Our ref: St Luke's Grammar School - Senior School Campus and Sports Centre (SSD-10291)

2 June 2022

Subject: Request for Additional Information

DRAWING TITLE 224 HEADLAND ROAD LEVEL 0 PLAN_224		DRAWN BY RM + CE + EG
SCALES AT A1		CHECKED PT
PHASE SSDA	DRAWING NO A-100	DATE October 2019
		REV A

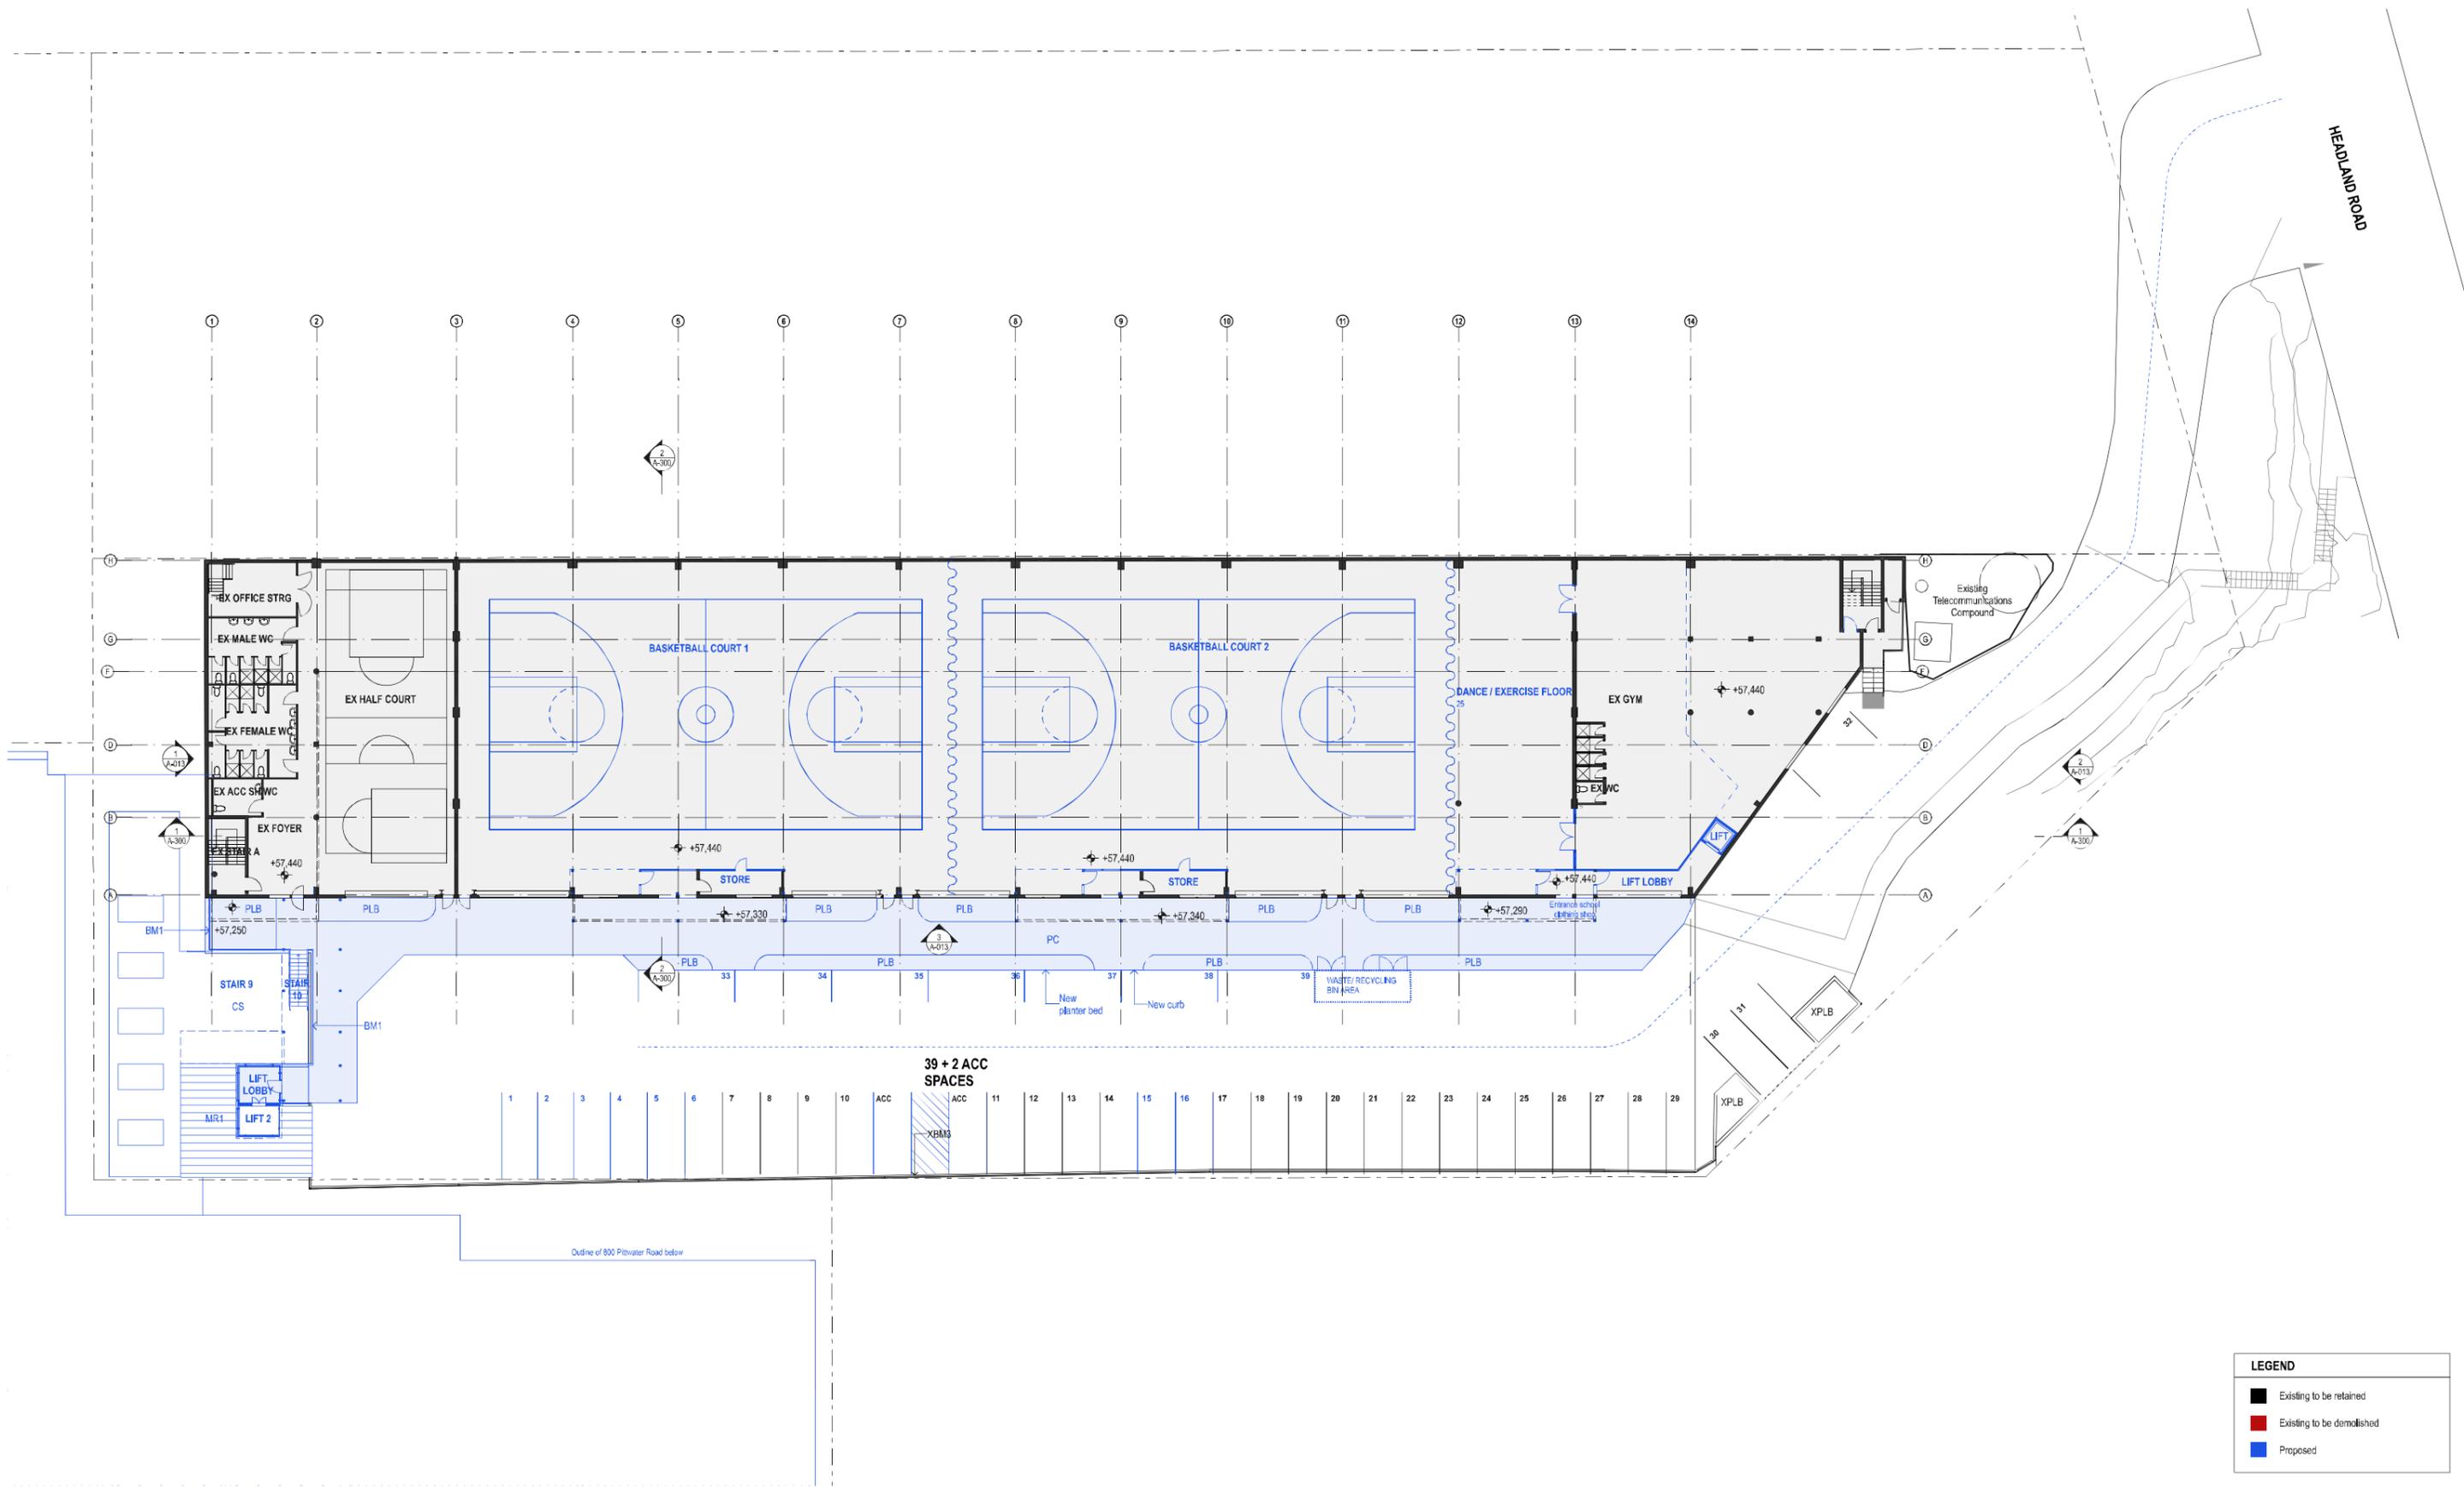
In the light of the above observations and comments from TfNSW, the Department requires the Applicant to provide a drop-off/pick-up zone for the senior school students within the Sports Centre (224 Headland Road) in lieu of the 39 car spaces allocated for Year 12 students.

- fully detailed and dimensioned options of alternate drop-off/pick-up facilities within 224 Headland Road, as detailed in the above paragraphs. Parking and kiss and drop shall be prepared to meet relevant Australian standards with suitable separated pedestrian walkways between the kiss and drop area to building entrances to sure that pedestrians do not have to cross vehicle paths of travel after students leave the car located in the kiss and drop space.

- a layout of the drop-off/pick-up area and carpark within 224 Headland Road, being fully compliant with the relevant Australian Standards.
- an adequate turning circle or manoeuvring area for drop off/pick-up at the Sports Centre to ensure students do not need to walk within the path of vehicles, either forward or reversing.
